Re: Waterloo Metro Quarter Building 3 and 4 – City of Sydney Council Waste Responses

The purpose of this letter is to address City of Sydney Councils Waste Responses (72 & 74), as per the below:

15. Conclusion

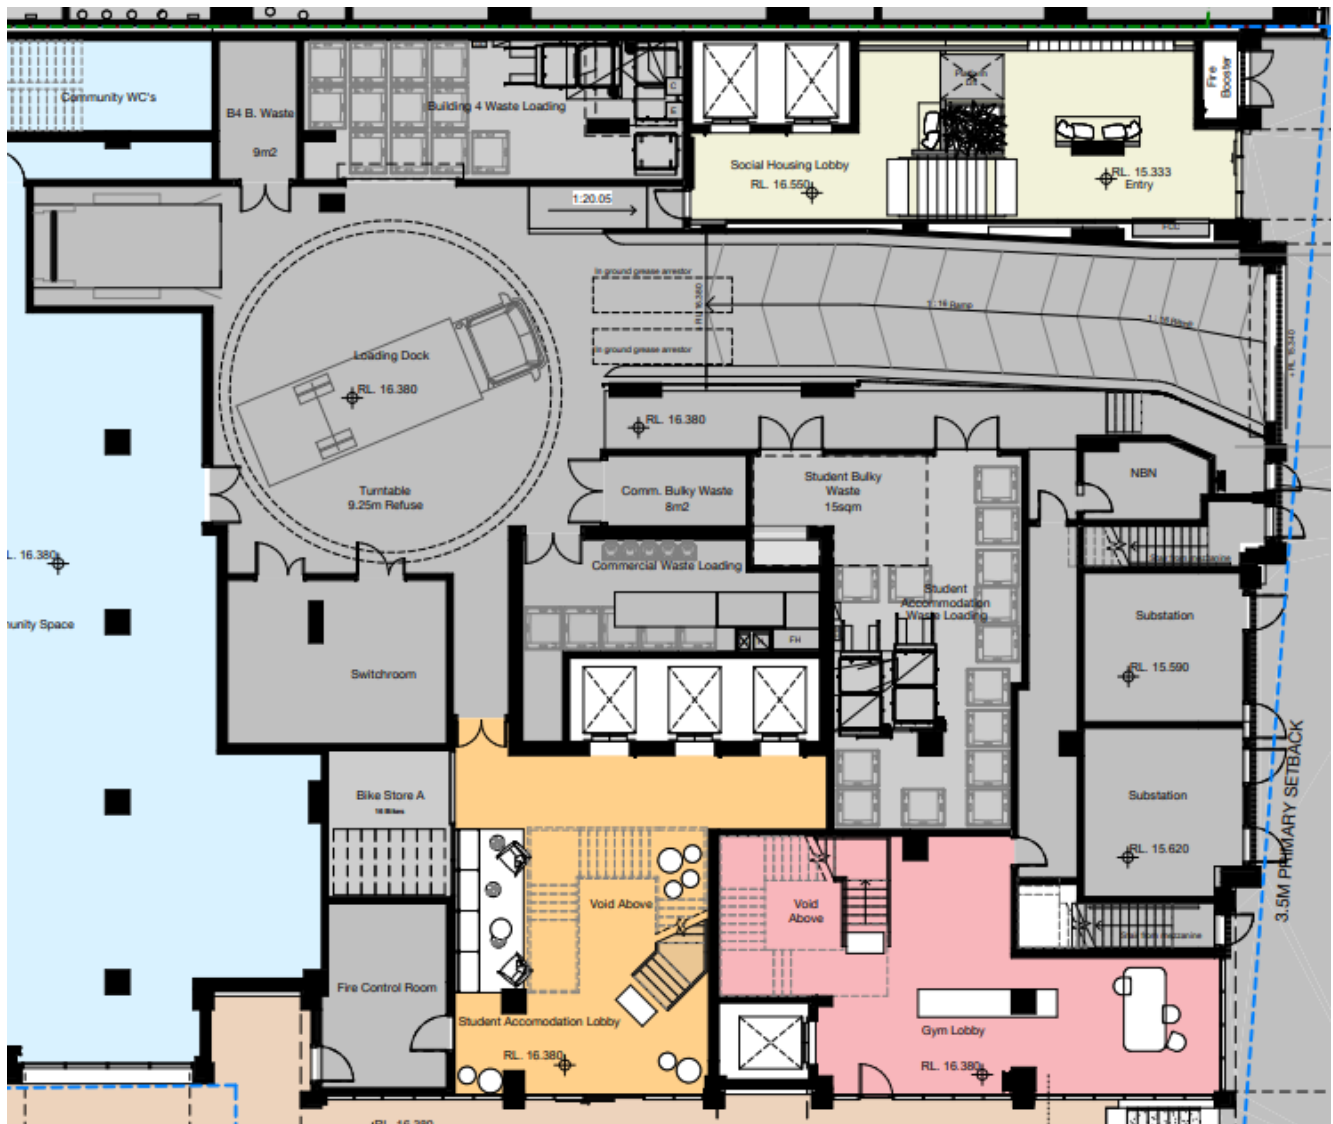
City of Sydney Response	Elephants Foot Recycling Solutions (EFRS) Response
<p>72. The City has developed a waste calculator to ensure development provides sufficient waste storage facilities in accordance with the City's Guidelines for Waste Management in New Developments. Please find attached a PDF with the estimated area required for waste bins. The City requests that the developer use the waste calculator and demonstrate that sufficient area has been provided to meet the needs of each use proposed on site. Please note that the City discourages more than 3 collections per week to minimise traffic movements.</p>	<p>EFRS notes that the waste calculator will not be entirely accurate for some waste rooms, as it does not account for waste management equipment, including linear track systems and compactors etc, which require additional space. It is also prominent that some calculations do not align with City of Sydney Council's <i>Guidelines for Waste Management in New Developments 2018</i>, hence there are inconsistencies in information. EFRS have based calculations in the Operational Waste Management Plan (OWMP) off Council's <i>Guidelines for Waste Management in New Developments 2018</i>.</p> <p>A comparison of spatial advice derived from City of Sydney Council's waste calculator and actual waste room sizes based off the architectural plans for each waste area are provided below.</p> <p><u>Social Housing Waste Room</u> Calculator: 18.6m² Area Provided: 43m²</p> <p>The additional area provided is to accommodate 2 x 2-bin linear track systems for 1100L bins, hence this room complies with the waste calculator.</p> <p><u>Social Housing Bulky Waste Room</u> Calculator: 10.5m² Area Provided: 9m²</p> <p>The area provided was calculated using the <i>Guidelines for Waste Management in New Development 2018s</i>, however upon reviewing the calculator an additional 1m² has been provided in the architectural plans for textile waste storage, hence this room complies with the guidelines.</p> <p><u>Boarding House Waste Room</u> Calculator: 53.1m² (based off 3 x weekly collections which is the maximum option available) Area Provided: 48m² (based off 5 x weekly collections)</p>

<p>74. It is noted that the development does not currently provide for separate food waste collection, contrary to the guidelines. Sufficient space must be provided for food waste for each relevant use. The City is trialling a food waste collection service and the developer is encouraged to make provision for this service, rather than providing on-site composting which in the City's experience is likely to fail. Again, the <i>Guidelines for Waste Management in New Development</i> provides suitable provisions.</p>	<p><u>Social Housing</u> Should City of Sydney Council's food waste trial progress to a Council service during operation of the site, the social housing component will consider options to integrate separate food waste facilities into the facility. Food waste generation rates, available bin sizes and collection frequencies are not readily available at this stage in the <i>Guidelines for Waste Management in New Developments 2018</i>.</p> <p>Based on the food waste generation rate available for single dwellings (40L/dwelling/week), 8 x 120L bins would substitute 1 x 1100L general waste bin. If the substitution of general waste bins to food waste bins is to occur during operation, 8 x 120L food waste bins will be provided in the social housing waste room for residents to access and dispose of their food waste. The chutes and linear track systems must be caged off from these bins, with access granted to authorised personnel only.</p>

<p>2 x 2-bin linear track systems for 1100L bins are provided in this waste room, hence the calculator does not capture this.</p> <p>5 x weekly collections are the preferred option, and the PTC have advised that 5 x weekly collections will have no impact on traffic congestion. IGLU boarding houses typically have a building manager onsite 24/7, who will monitor the capacity of bins and schedule in collections when required. Generally collections of up to 5 x weekly are typical for these sites to maintain a high standard of cleanliness in the facility.</p> <p>Boarding House Bulky Waste Storage (caged off) Calculator: 8m² Area Provided: 15m²</p> <p>The area provided was calculated using the <i>Guidelines for Waste Management in New Developments 2018</i>, hence it is compliant with the guidelines but inconsistent with the waste calculator requirement.</p> <p>Commercial Waste Room Calculator: 22m² Area Provided: 28m²</p> <p>The area provided is based off 5 x weekly collections, yet it is still greater than the waste calculator requirement. To ensure that all bins are accessible, a greater area than 22m² is required.</p> <p>Commercial Bulky Waste Room Calculator: 8m² Area Provided: 8m²</p> <p>This is compliant with the waste calculator.</p>

<p><u>Boarding House</u></p> <p>The provision of food waste has been considered in the boarding house calculations and bin summary; however, food waste has been included with the general waste stream in the Operational Waste Management Plan and will be managed with general waste.</p> <p>Should the boarding house operator elect to separate food waste from general waste during operation, this provision has been allowed for and 38 x separate 120L food waste bins will be provided in the waste room to substitute 4 x 1100L waste bins. These food waste bins will be caged off at the southern end of the waste room and a door will be inserted to provide access to students if this is to occur.</p> <p><u>Commercial</u></p> <p>Due to the commercial component having dining/kitchen areas, food waste has been considered and separated from general waste in the OWMP.</p> <p>5 x 120L separate food waste bins have been provided in the commercial waste room.</p>
